Re: Status of Improvement Permit Application #06-5-14013

Lot 15 Cherokee Ridge

CHEROKEE RIDGE SUB.  
PHASE TWO  
LOT #15 - 0.53± ACRES

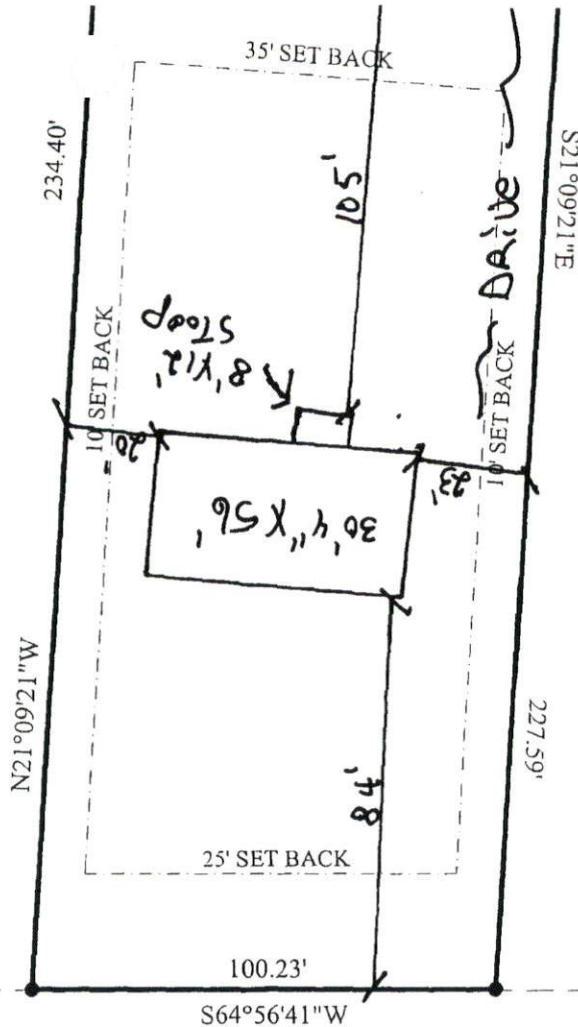
- 1. Property lines/corners not marked or labeled
- 2. House corners not marked or labeled
- 3. Directions not clear to property
- 4. Property needs brush or vegetation removed
- 5. Backhoe pits required
- 6. Other – **Please move house back as shown on attached sheet.**
